2022/0868

Conversion of barn into annex

Roger Royd Farm, Whin Moor Lane, Silkstone, Barnsley, S75 4NL

GROUND FLOOR PLAN
AS PROPOSED

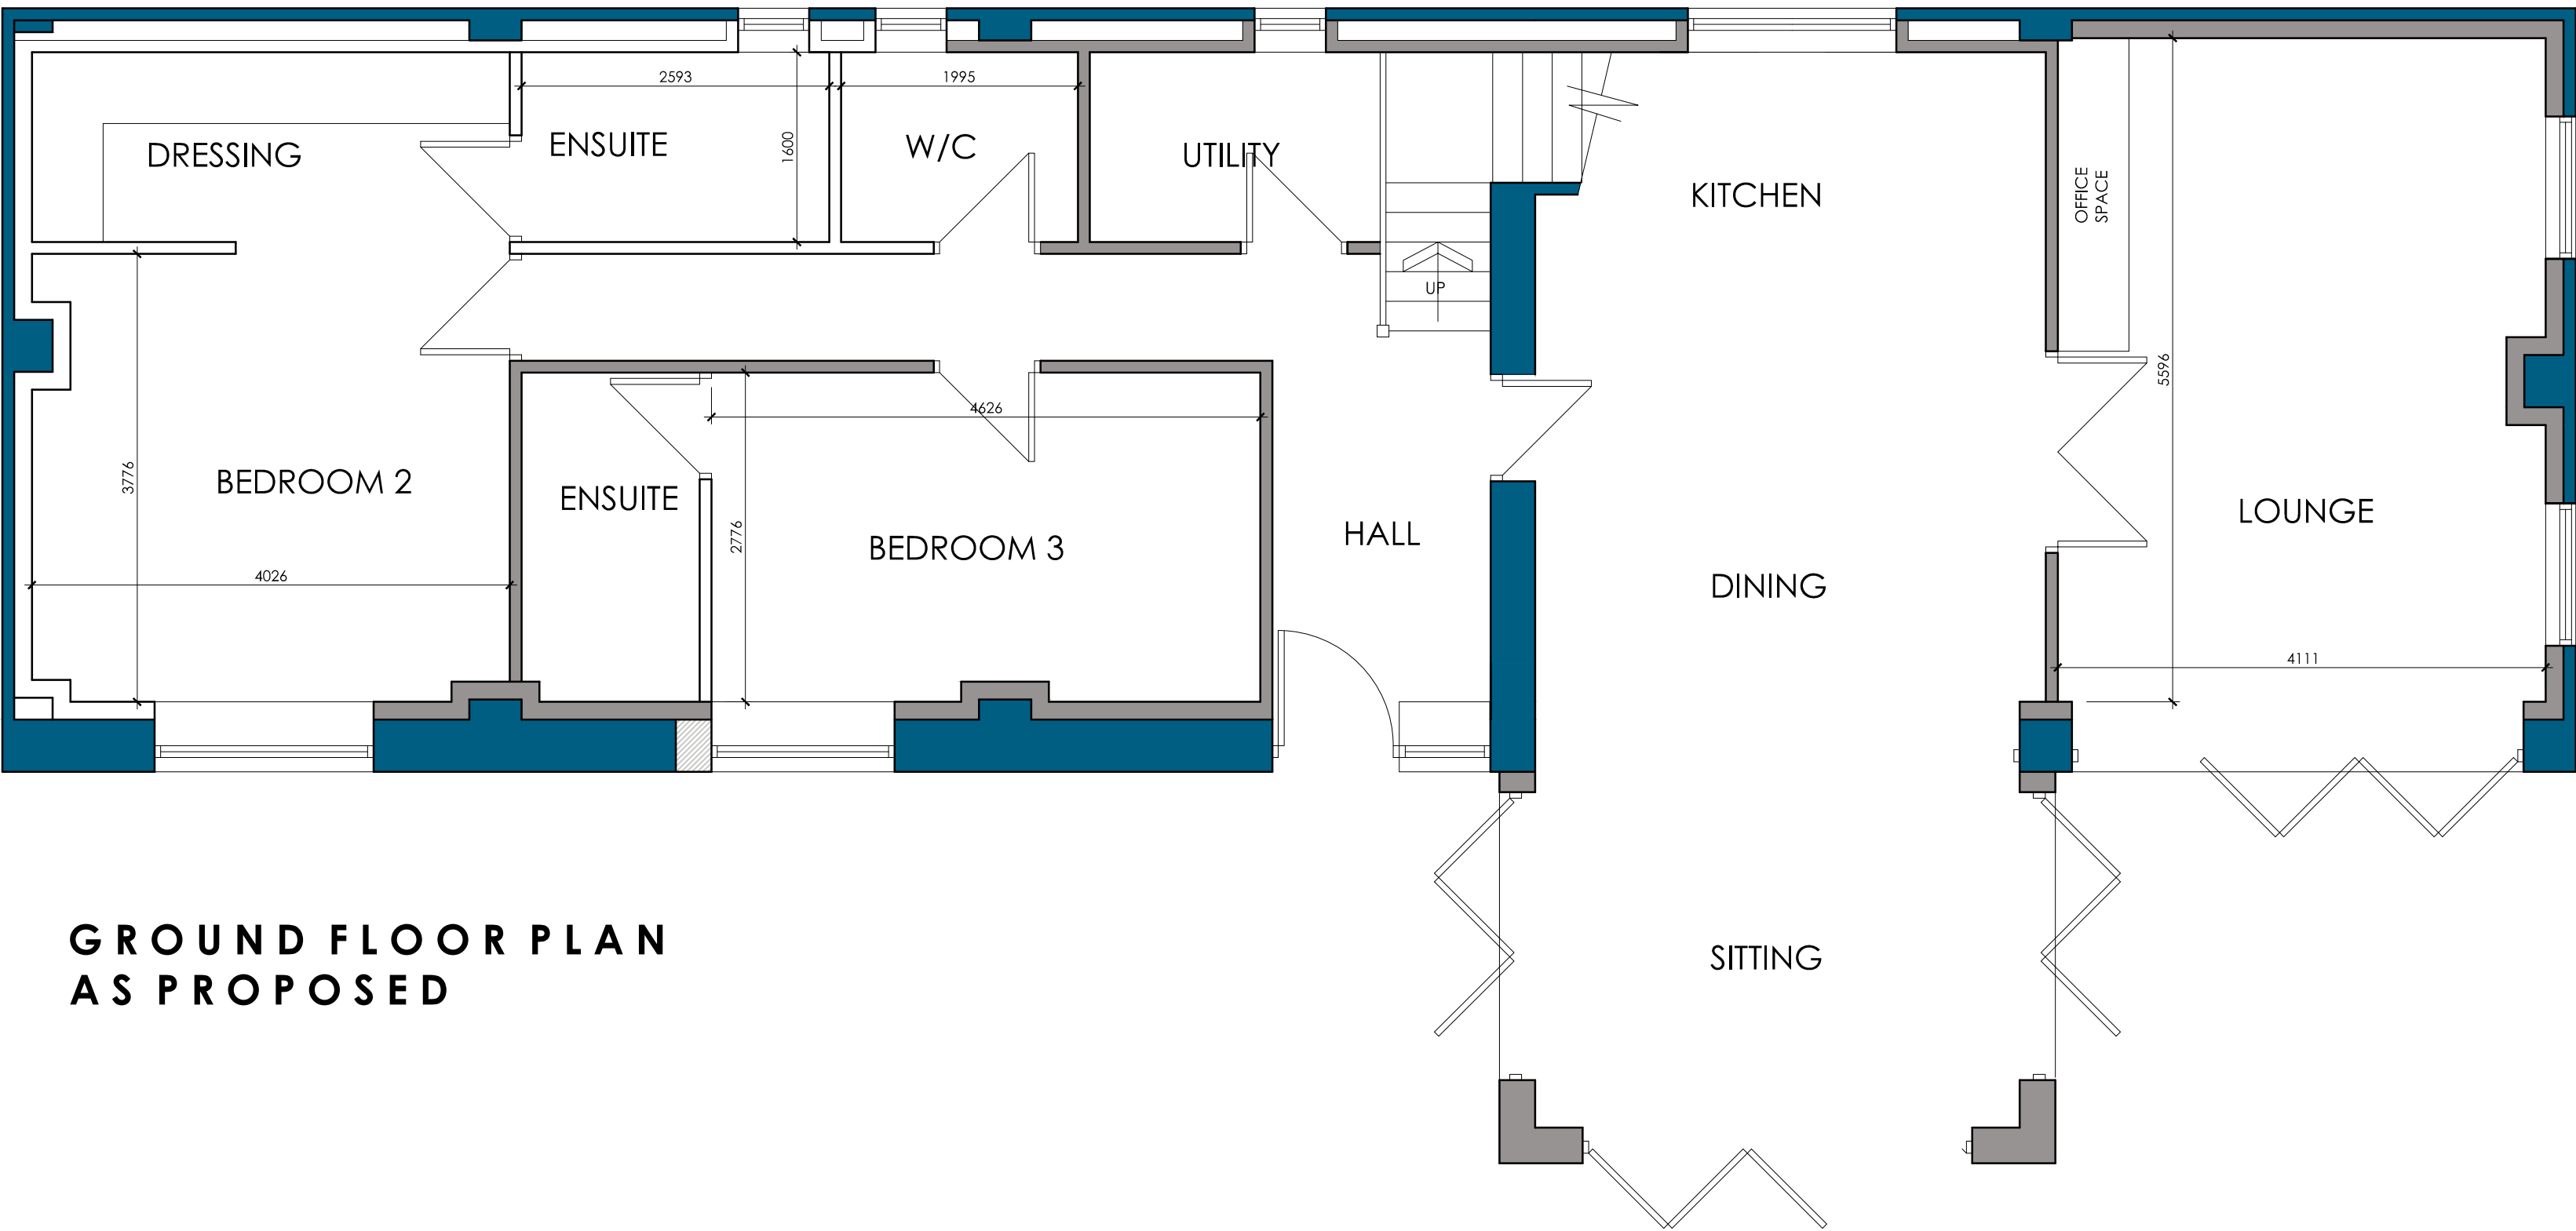
and internal alterations. The floor area of the building would be approx. 123sqm with a large bedroom, separate bathroom and a large kitchen/living/diner. The Plans also show a curtilage around the property with a shared access and a separate parking area.

Although the proposal seeks a change of use of the building to an annex rather than a new building the principles of the association to the main dwelling and size of the annex given within the SPD are still considered to be applicable. The proposal fails to comply with the above guidance. The proposed conversion has been designed with no more than 3 rooms, however the room sizes are significant and the building would have its own private garden area/curtilage and separate parking spaces. The building does not have a close physical relationship with Roger Royd Farm as it is outside the curtilage of the property and has the appearance of a separate dwelling. The proposed building would have a large internal floor area of 123sqm which is more than the average size of a family home.

The above SPD guidance limit annexes to three rooms, irrespective of size. The provision of a bathroom, kitchen and living areas, in addition to the large bedroom area would mean that there is no reliance upon the main dwelling for any typical residential facilities. Due to the range of facilities proposed for the unit, internally and externally, which is akin to an average sized family dwelling, it is clear that the proposed annex could be used as an independent residential unit and separate to Roger Royd Farm. The proposal is therefore contrary to the SPD House Extension and Other Alternations guidance, which states that annexes should have a close physical relationship with the main house. The proposal would also effectively be an extension to the curtilage of the existing dwelling which is considered to be contrary to the NPPF and Policy GB1 of the Local Plan.

The plans originally proposed to convert the building into a separate dwelling, however due to highway safety issues with the access, the applicant now proposes to use the building as an annex only. The curtilage of the annex has also been reduced and the internal spaces altered to 3 rooms.
